CITY OF ALBUQUERQUE

August 2, 2013

Re: Four Hills Park Grading and Drainage Plan
Engineer's Stamp date 06-25-13 (M22/D008)

FOUR HILLS VILLAGE PARK GRADING AND DRAINAGE PLAN

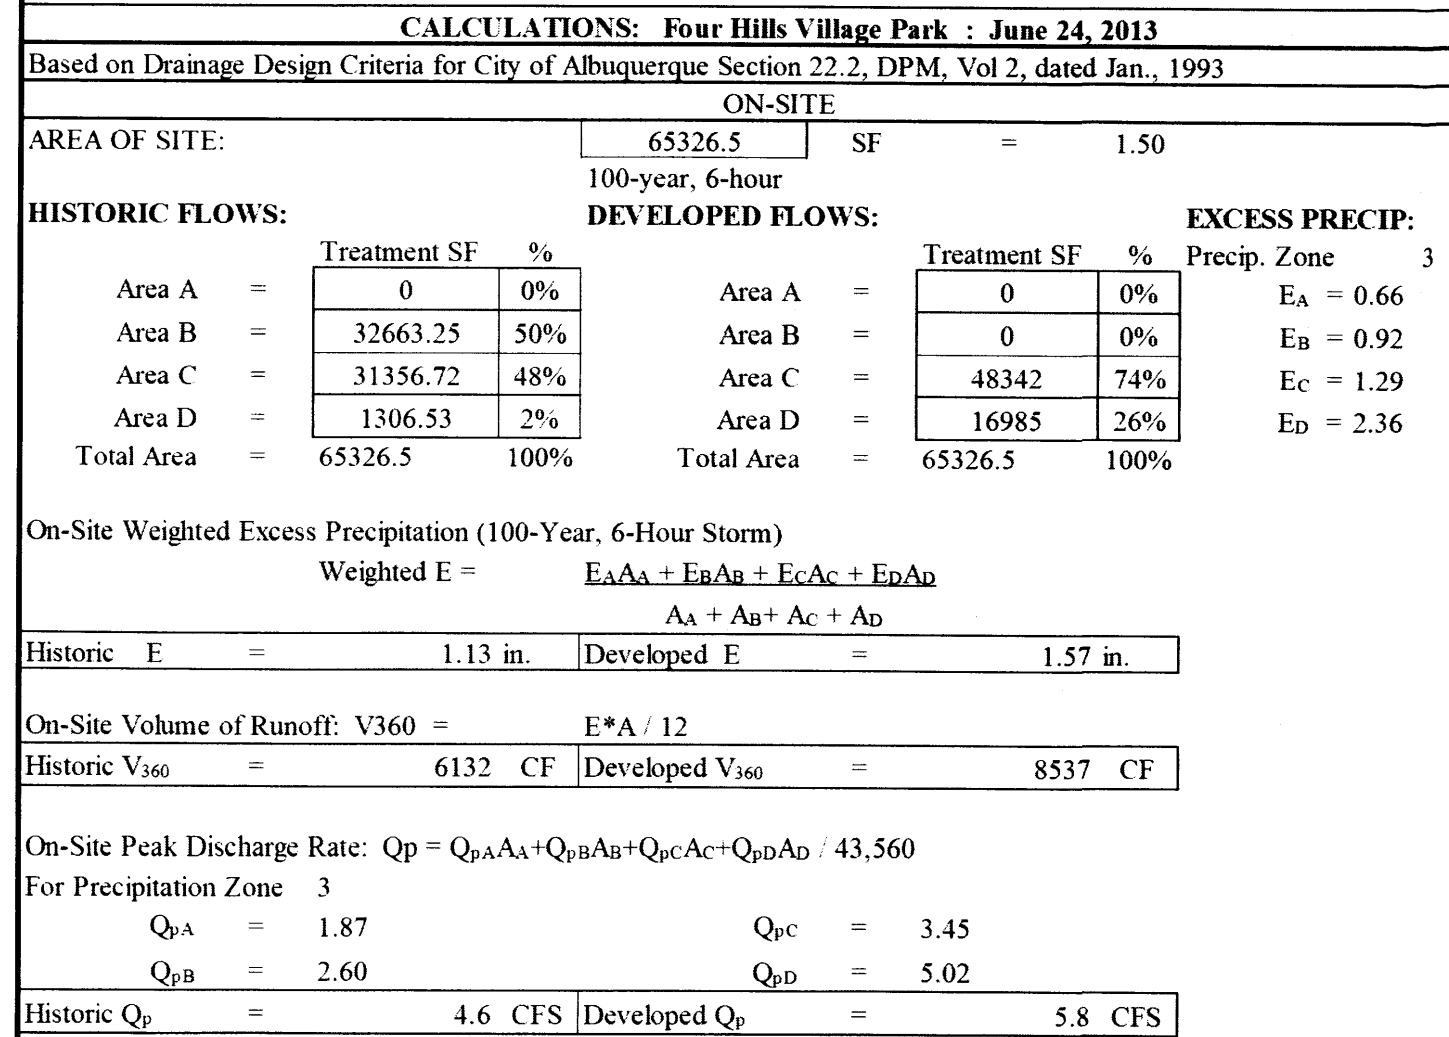
- Is there a public drainage easement on the property to the north?
- Are there any offsite runoff entering the park?
- Please angle the discharge point away from the pole located at the northwest corner of the property.
- Please increase the size of the existing spot elevations and contour labels. A retaining might be required at the southwest corner of the project.
- Provide flow numbers at the two dicamount of runoff being discharge at the two curb openings on the north side of the project? The concentrated runoff will create erosion. Can we spread the discharge over a wider area?
- What is the runoff volume being retained within the water harvesting areas?
